DOC18/849109

**RE: Genesis Waste Management Facility (MP 06_0139 MOD 6) – Request for Comment –
Further Comments on Air Quality Impact Assessment**

ATTACHMENT A

Figure 4-1: Annual wind rose for Horsley Park BoM site – 2012 - 2016

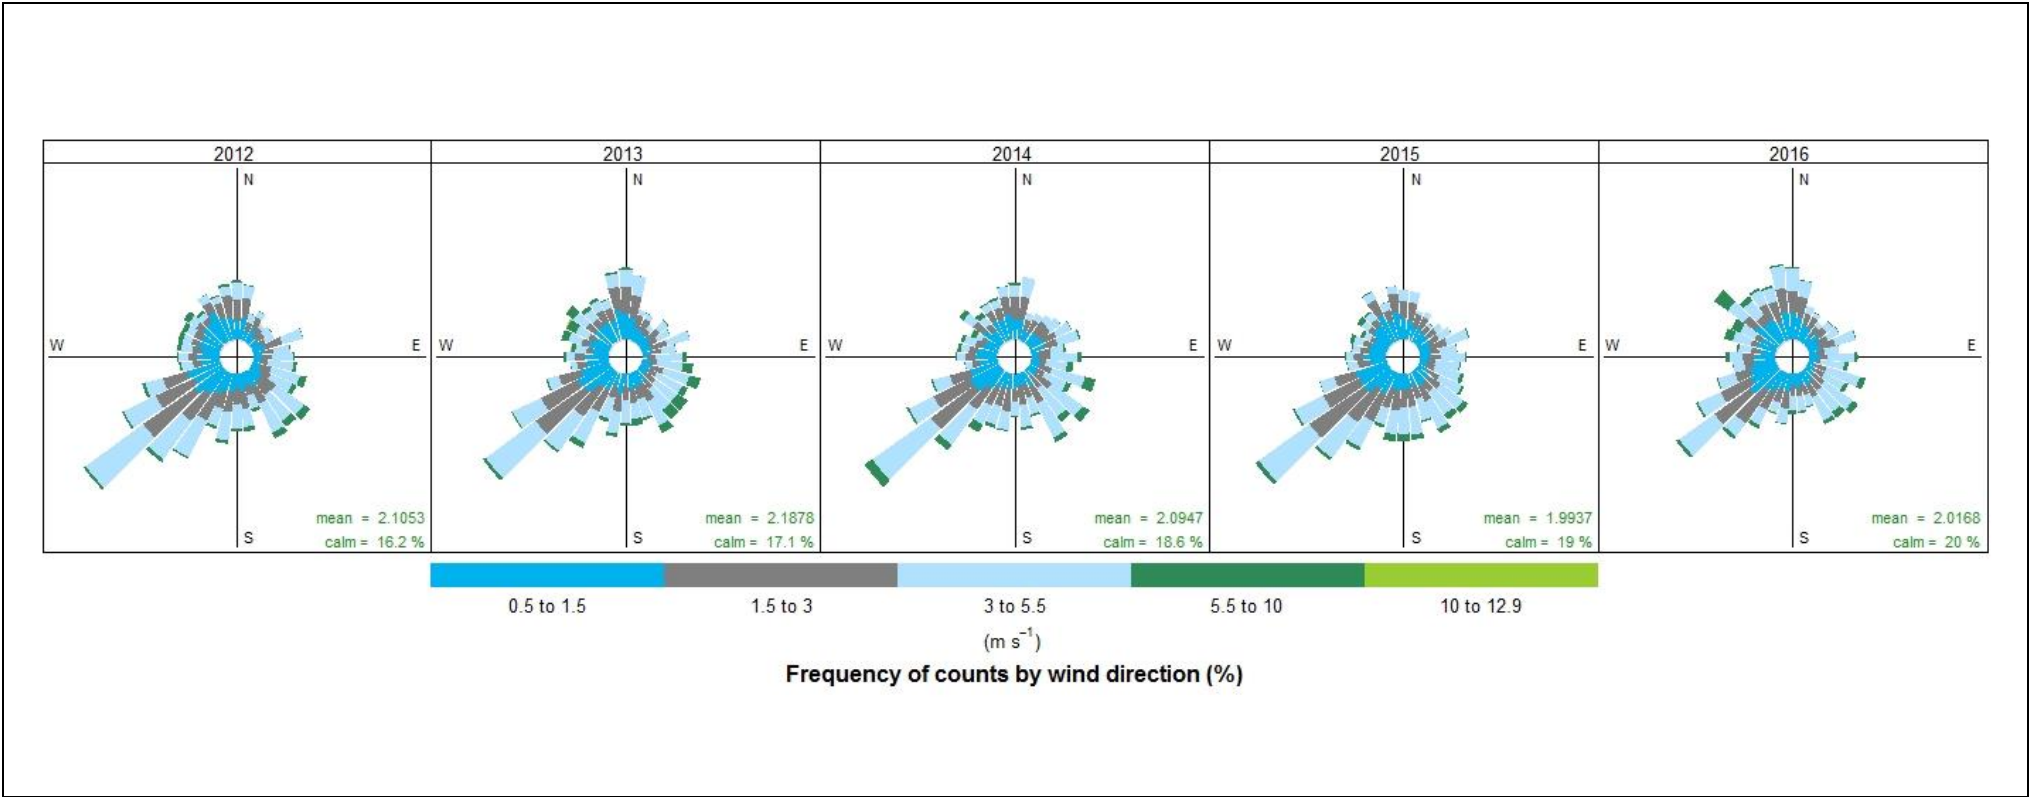
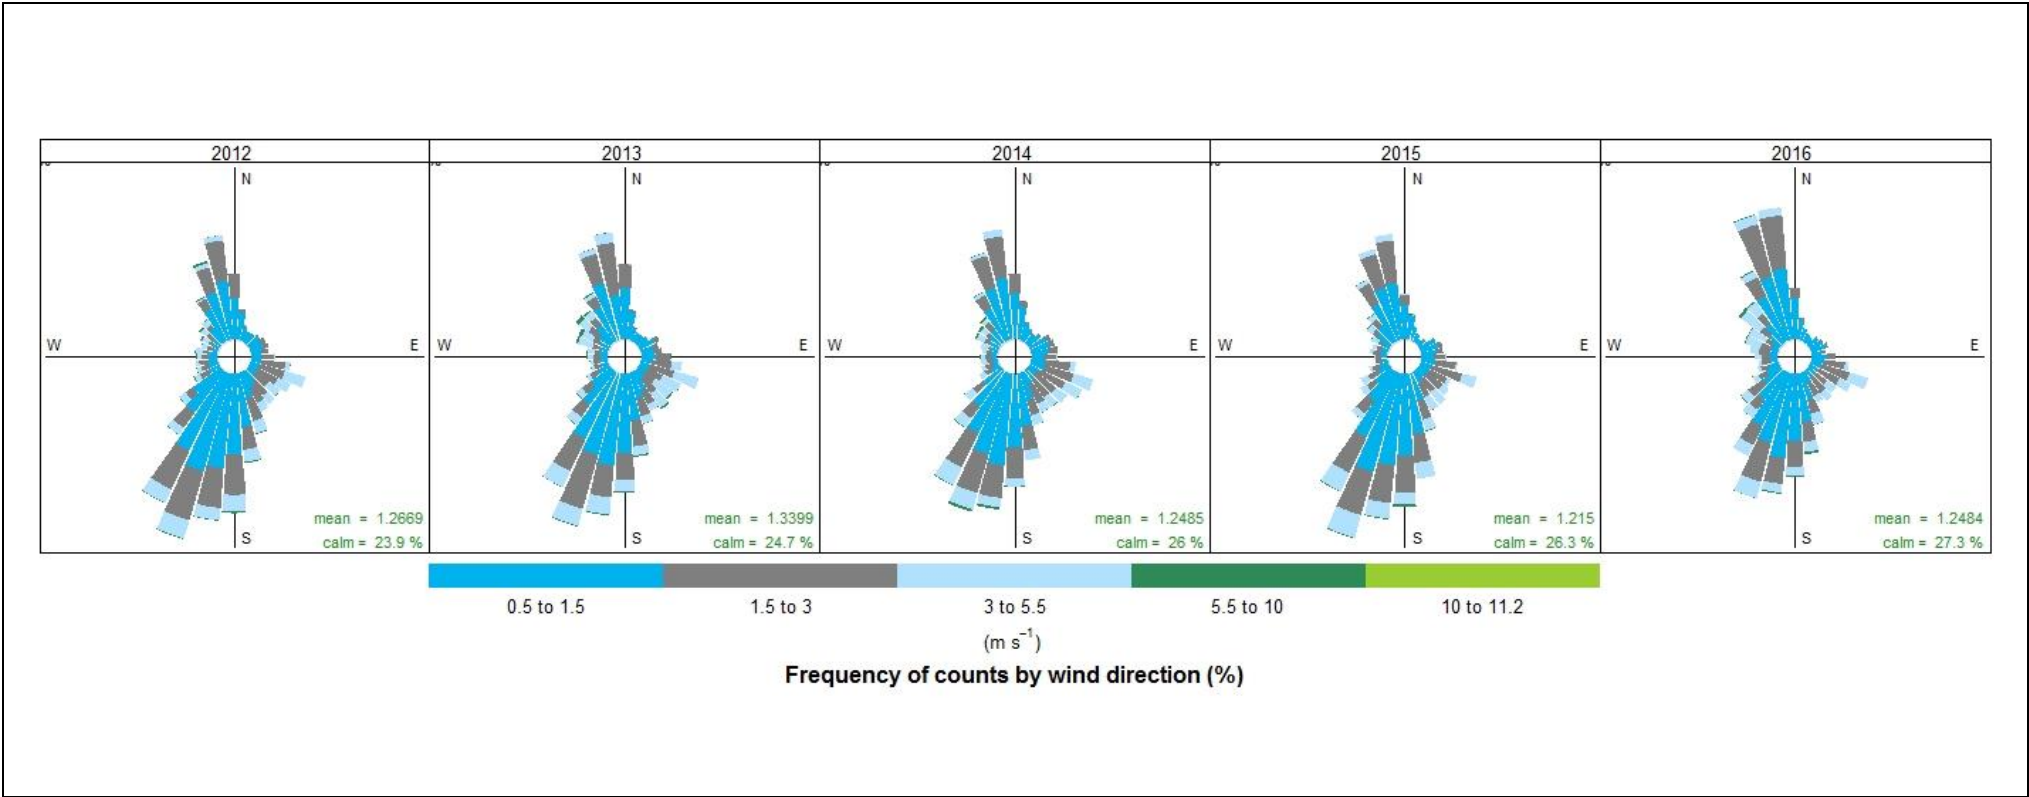
Consideration should be given to other meteorological parameters such as wind speed and wind direction to demonstrate the appropriateness of the selected year for meteorological/dispersion modelling. The proponent must provide an analysis of wind speed and wind direction data from an appropriate meteorological station to demonstrate 2016 is appropriate for modelling purposes.

Ramboll 2018 presents five years of meteorological data from the Horsley Park and St Marys Bureau of Meteorology stations. Data from these meteorological stations for 2012 to 2016 (inclusive) are presented as wind rose diagrams. The assessment advises that the wind roses demonstrate a high degree of consistency in winds across the five years, in terms of wind direction, average wind speeds and percentage occurrence of calm conditions.

Figure 4-5: Comparisons of observed and CALMET predicted winds for the Badgerys Creek BoM site

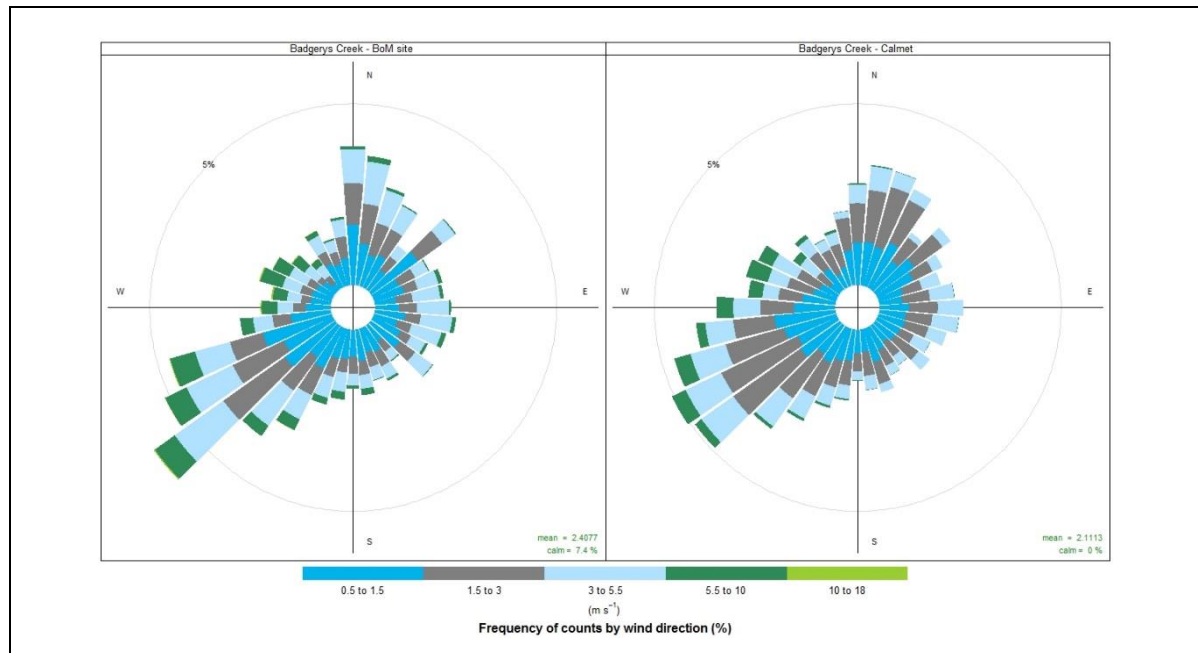
Ramboll 2018 advises that evaluation of CALMET predicted winds was conducted by comparing the CALMET model results, without data assimilation for the Badgerys Creek Bureau of Meteorology (BoM) site, with the actual meteorological data collected at Badgerys Creek. A general qualitative comparison and discussion between the data sets is provided. This method would seem appropriate however the EPA understands that the CALMET data used for predicting potential air impacts is based on data assimilation using the Badgerys Creek BoM data. Hence the comparison does not seem to be based on the actual CALMET data used for predicted air quality impacts.

Figure 4-6: Comparisons of CALMET winds for the Genesis site with Prospect OEH

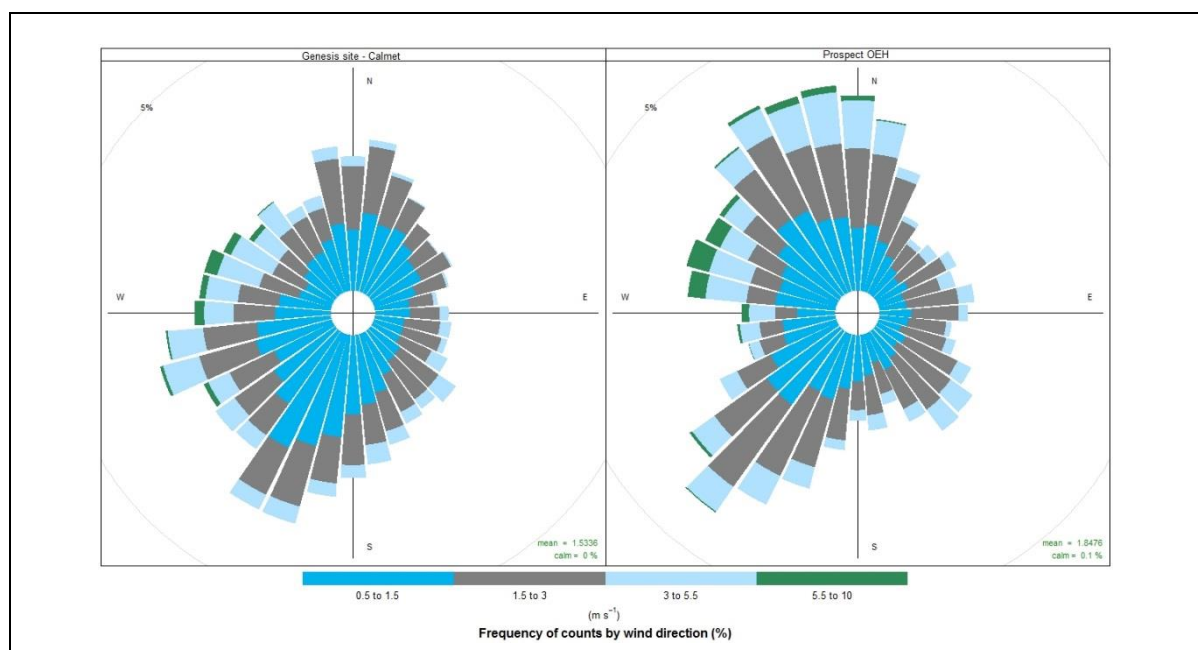
Additionally, Ramboll 2018 includes a comparison of CALMET predicted winds at the site with the Prospect meteorological station (located approximately 8 km to the east), which has not been used as a site for data assimilation. A comparison of CALMET predicted data with an actual data set not used for data assimilation would be appropriate, however the data sets for the comparison should be for the same location. Given the distance between the two sites where the data is collected/extracted, the comparison is not considered robust for validating the CALMET data.

Recommendation: Not adequately addressed. The CALMET predicted data at the Prospect meteorological station should be compared with the Prospect meteorological data set.

Figure A5-6: Predicted Project-only annual average dust deposition (g/m²/month)

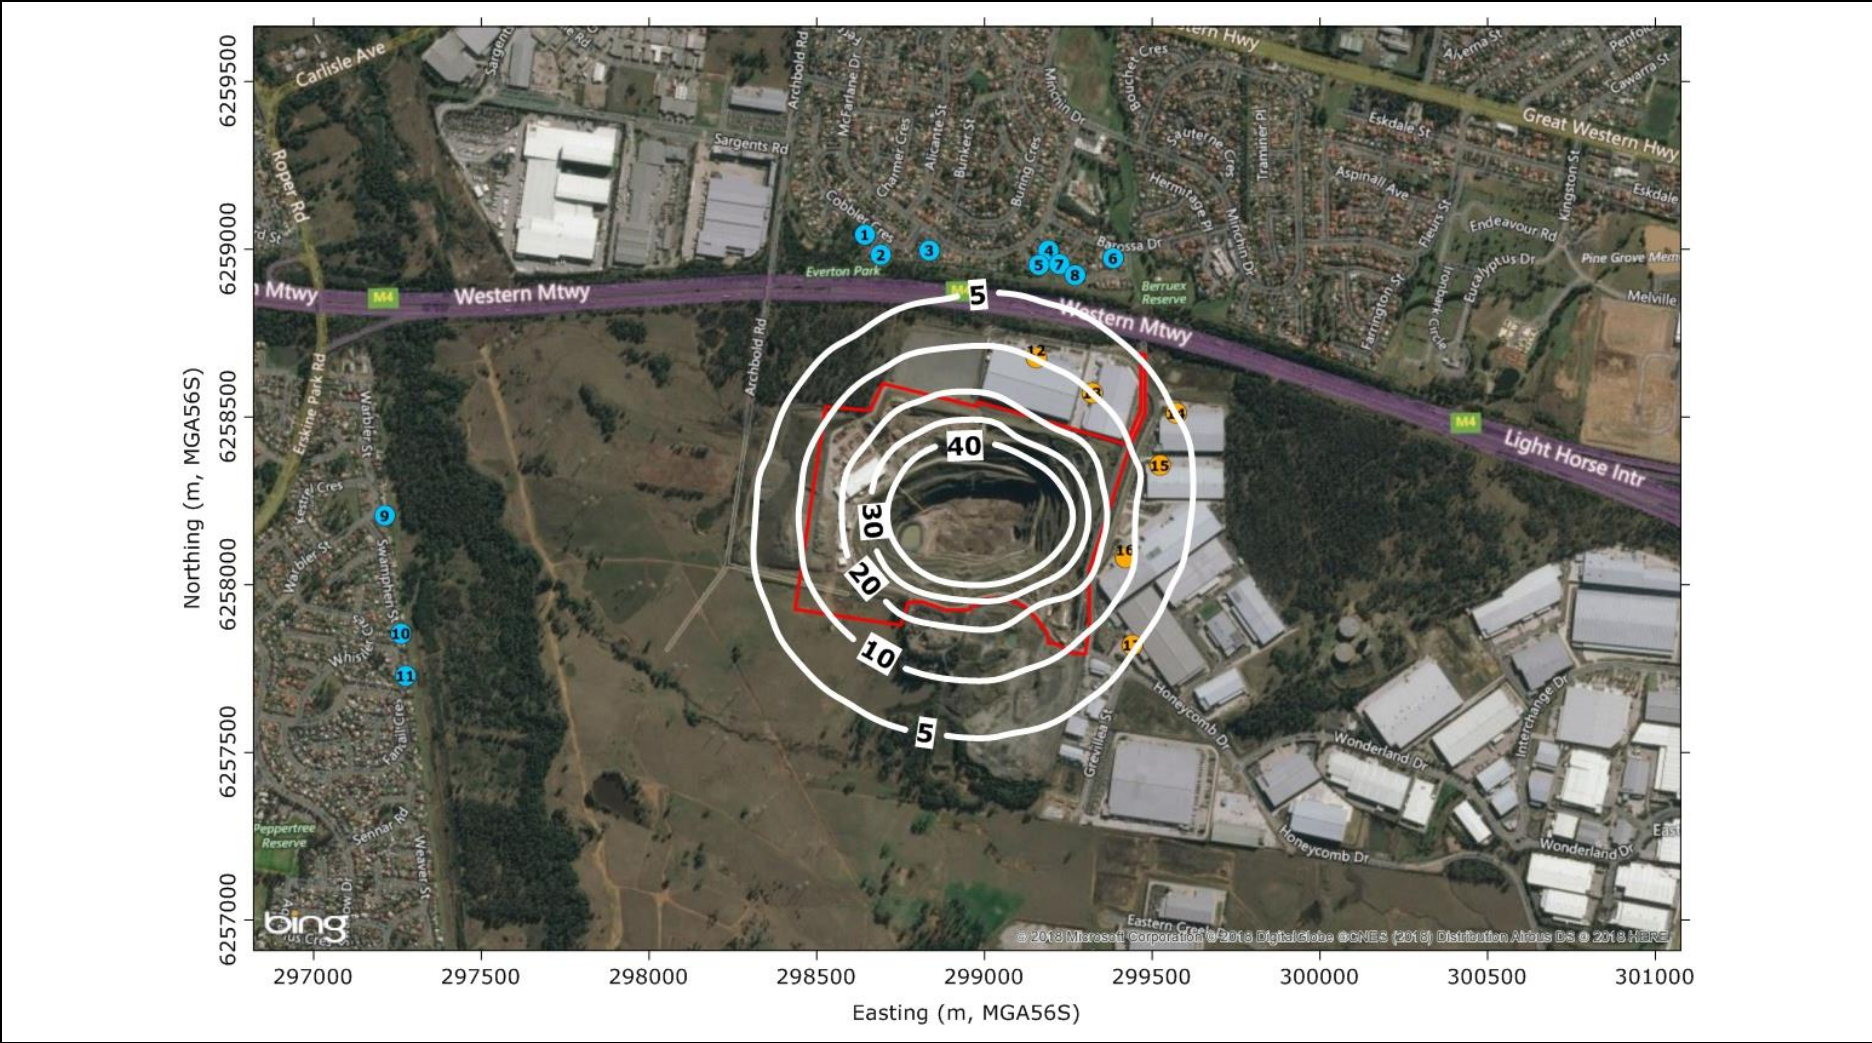
5. The isopleth for deposited dust does not align with the tabulated predicted deposited dust impacts. The predicted dust deposition impacts should be reviewed and confirmed.

Concentration isopleths are provided for PM_{2.5}, PM₁₀, TSP, deposited dust and odour within Appendix 3 of Ramboll 2018. The isopleth for deposited dust does not align with the predicted impacts in Section 7.3 of the main report. The isopleths show significantly higher predicted impacts. The proponent should review the predicted impacts and isopleth to confirm the predicted dust deposition impacts.

Recommendation: Clarity be sort on the predicted dust deposition impacts noting the difference between tabulated deposited dust predictions and the isopleth in Appendix C.
